|    | Summary of Matters Raised                                                                                                                              | Proponent's Response

SITE PLAN

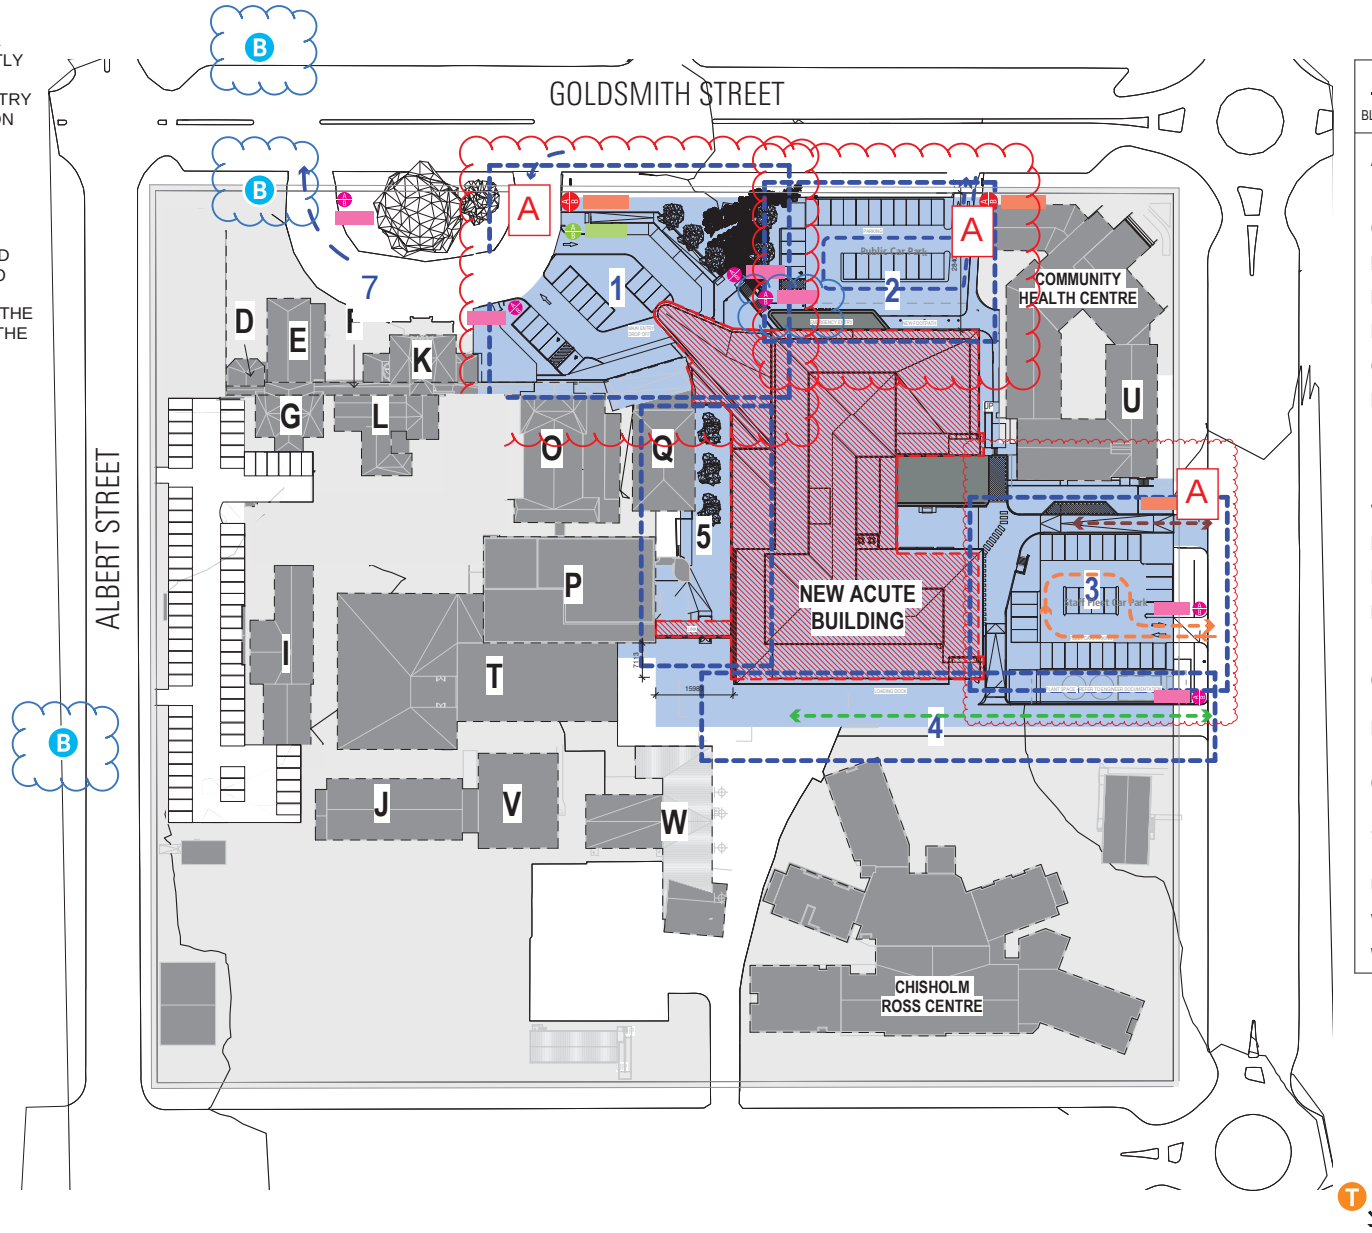
2. Include wayfinding strategies and travel access guides along with the signage modifications to assist with increasing the mode share of walking, cycling and public transport. It is recommended that wayfinding to the nearby bus stops at Goldsmith St and Albert St is included.

The Wayfinding and Signage Plans have been updated by Minale Tattersfield (Appendix 1) to include appropriate signage, guiding the hospital's visitors to the surrounding bus stops along Goldsmith and Albert Streets to encourage the use of public transportation. The proposed signage has also been amended to include wayfinding to the public bicycle parking areas, to encourage visitors to cycle to and from the hospital.
